Application for Planning Permission for Works or Extension to a Dwelling

Development Proposed conservatory to rear elevation.

Location 9 Cunningham Gardens Felpham

SITE PLAN 1:500

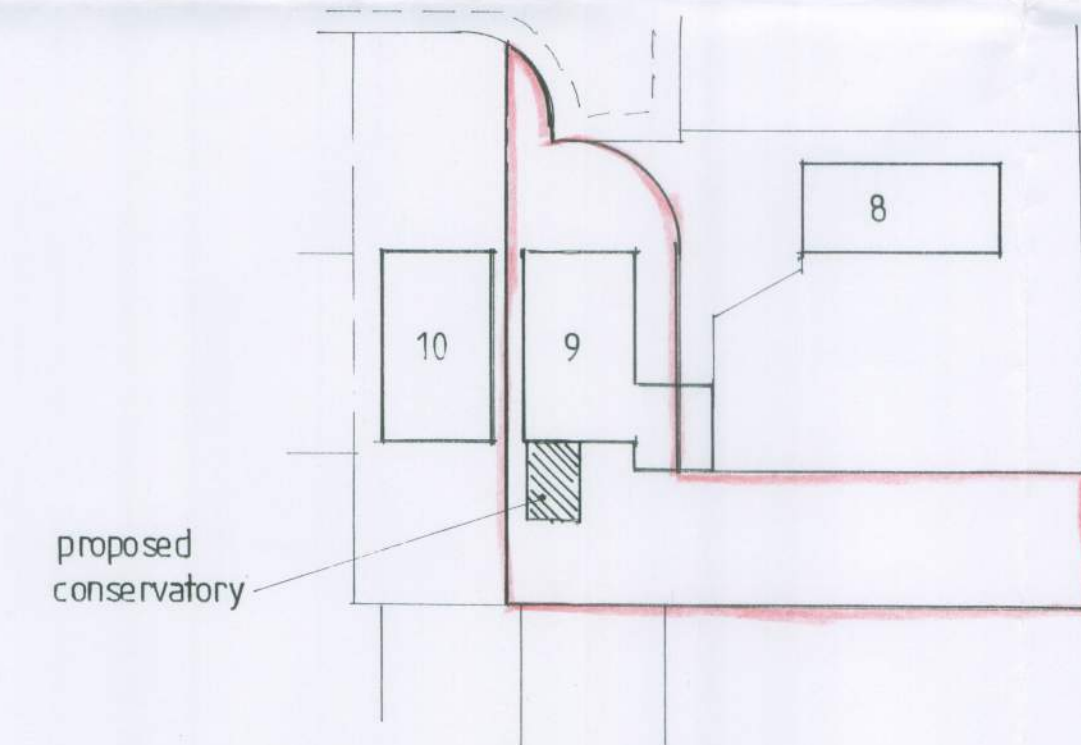
Block Plan

Please submit 1 electronic or 3 paper copies of a revised block/site plan at a scale of 1:500 or 1:200 with the boundary dimensions clearly indicated on the plan. Further details of what must be included on the plan can be found in the National Validation Requirements.
